CONSULTEE RESPONSE (Council's arboriculturist)

Reference: Y/36/22/HH

Proposal: Erection of detached workshop, gym/hobby and greenhouse. This application affects character and appearance of the Main Road/Church Road Yapton Conservation Area and a Listed Building

Location: Berri Court, Main Road, Yapton, BN18 0ED

Title
SITE PLANS

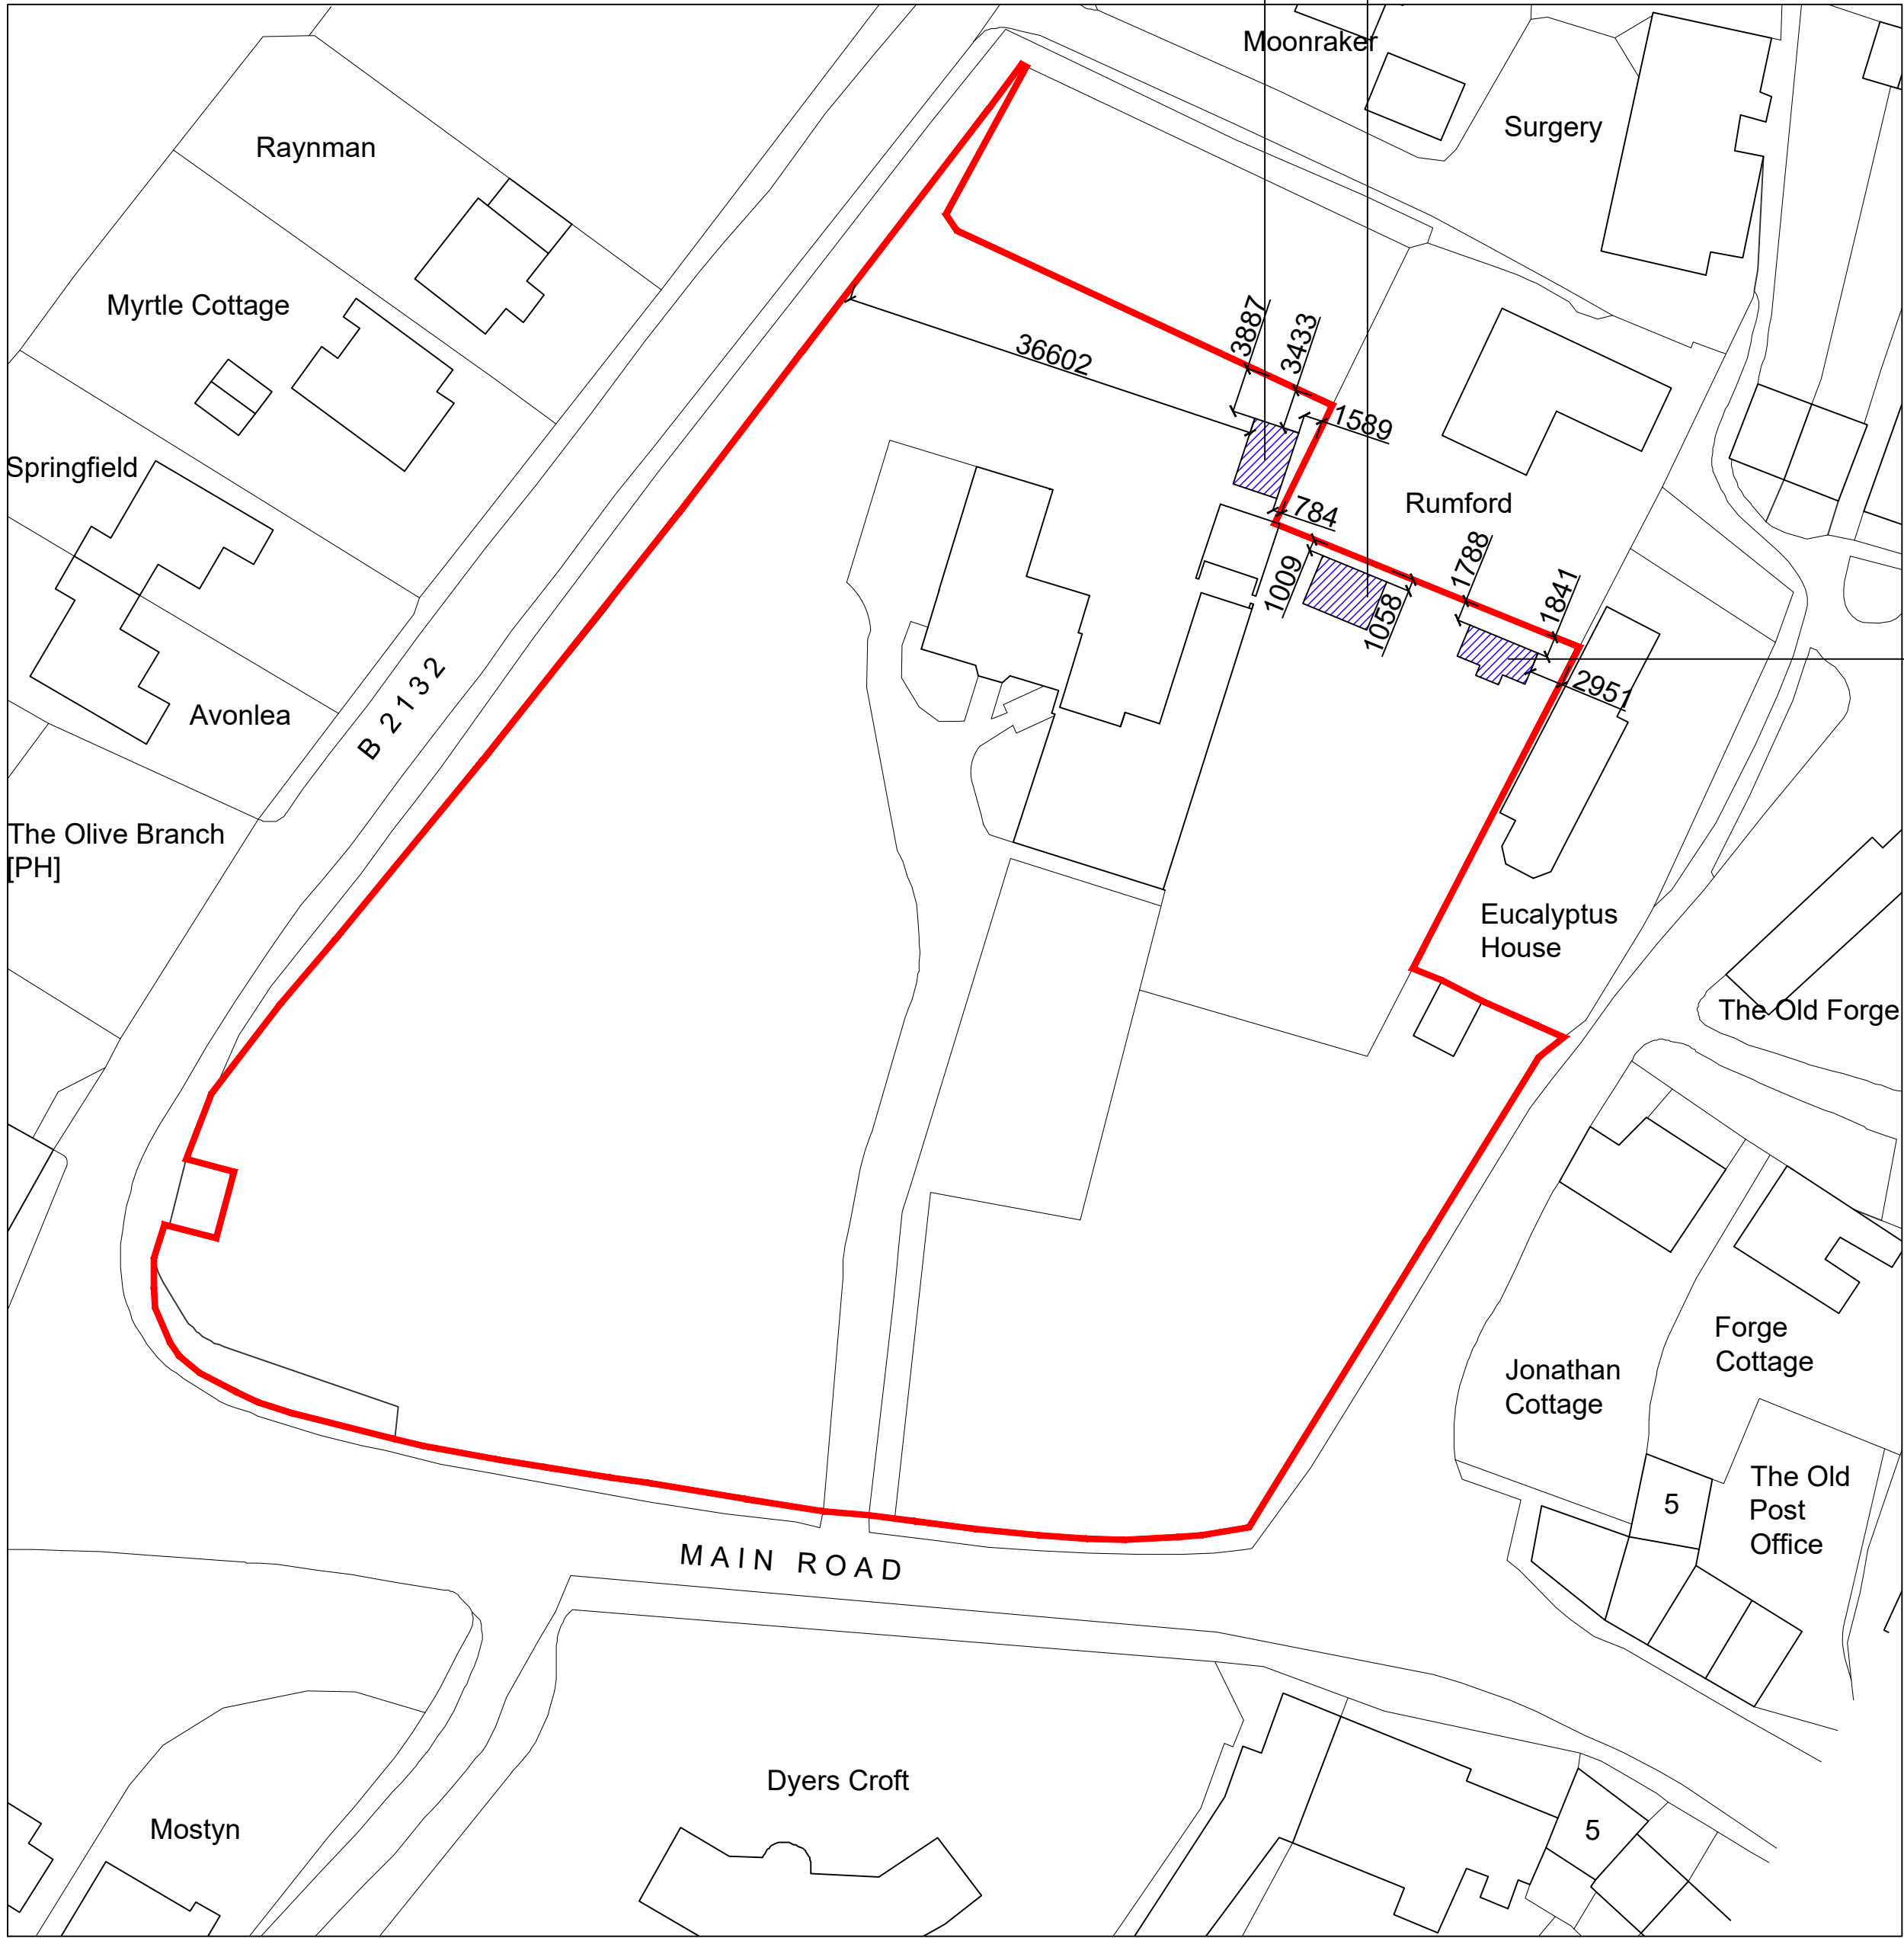
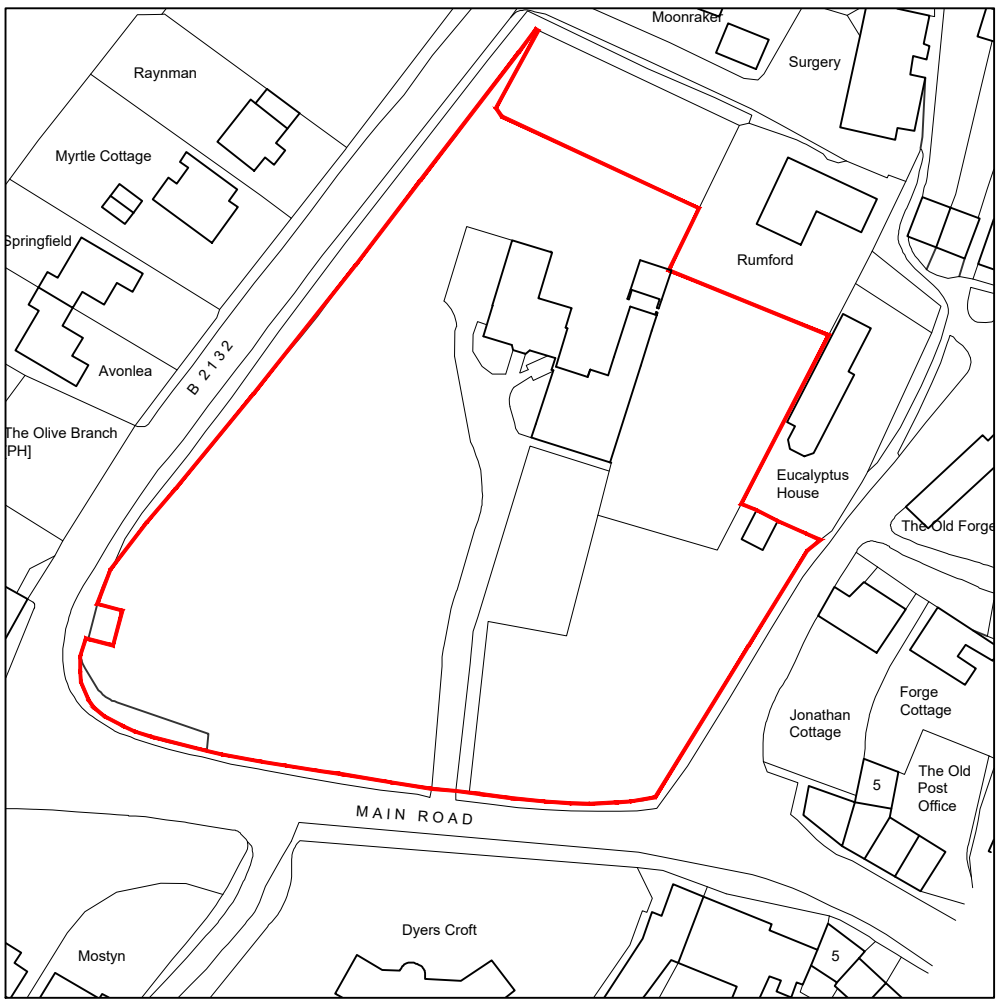
It has been stated on the application form that there are no trees or hedges on the proposed development site, nor on land adjacent to the proposed development site that could influence the development or might be important as part of the local landscape character. This is incorrect as from my own site observations there are several established on-site trees which are within influencing distance of the proposed gym/hobby room and workshop.

There is no supporting arboricultural information (including a Constraint Plan to illustrate the relationship between trees and building proposals) submitted with the application - a requirement of BS5837:2012.

There are significant trees overlapping the development which by virtue of their size enjoy statutory protection from growing in a Conservation Area. They could be adversely affected by these proposals. Were this application to proceed in current form, we would not have sufficient information to guarantee those trees would be adequately considered and protected.

The applicants will need to employ the services of an Arboricultural Consultant to carry out a tree survey exercise and then prepare an Arboricultural Impact Assessment (AIA) which must be inclusive of; a 'Tree Survey Schedule', a 'Root Protection Area (RPA) Schedule' and a 'Tree Constraints Plan' – with the trees accurately plotted on same.

If an RPA of any tree which is proposed for retention overlaps the development, then BS5837:2012 requires that the Detailed Planning Application is accompanied by an Arboricultural Method Statement (AMS) and most importantly a Tree Protection Plan – to both describe and illustrate the mitigation measures which are to be employed to ensure that the trees survive without detriment to their vigour and vitality and are given adequate protection both above and below ground.
